12 October 2016

NSW Planning & Environment
Fiona Gibson
Planner – Modification Assessments
fiona.gibson@planning.nsw.gov.au

Section 96(2) Modification to Development Consent (SSD 6913) for the redevelopment of Gosford Hospital

INDICATIVE SUBDIVISION
LAYOUT PLAN
Gosford Hospital

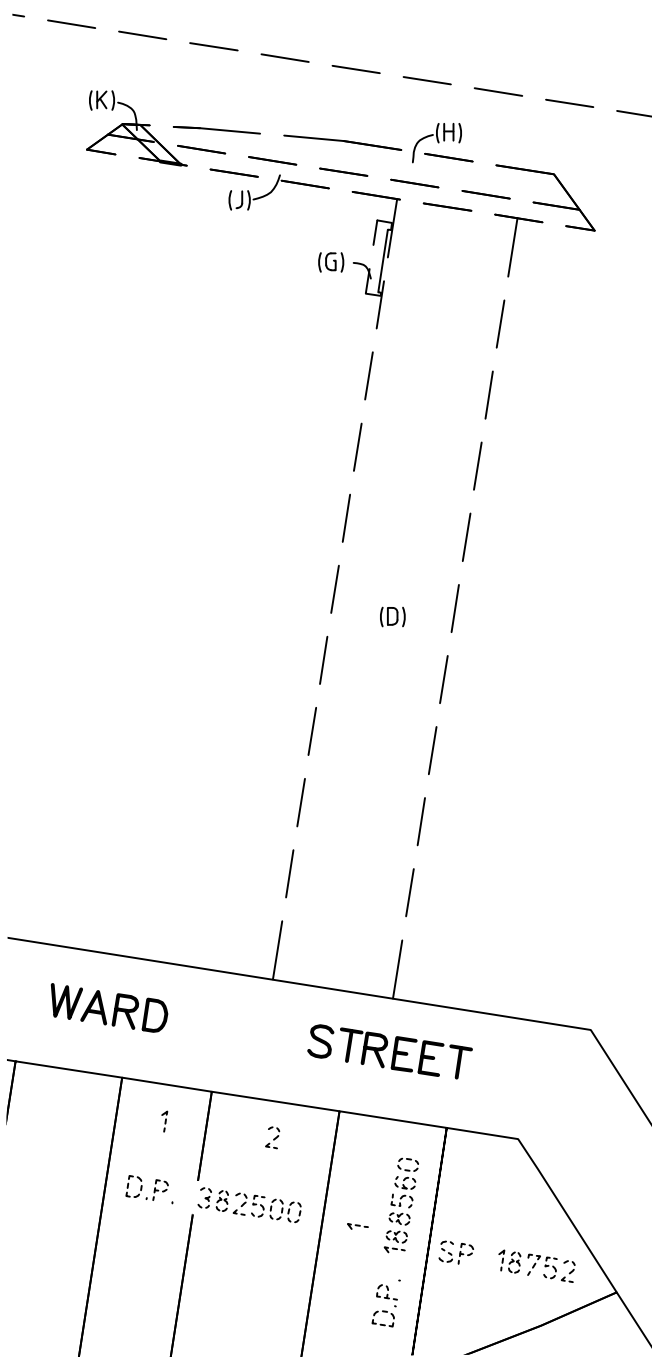
1. Conditions D7, D8 and D9 should be amended to reflect the new subdivision layout.
2. The relevant condition related to stormwater management should be amended to reference the Infrastructure Management Plan prepared by ADW Johnson dated 20 July 2016.
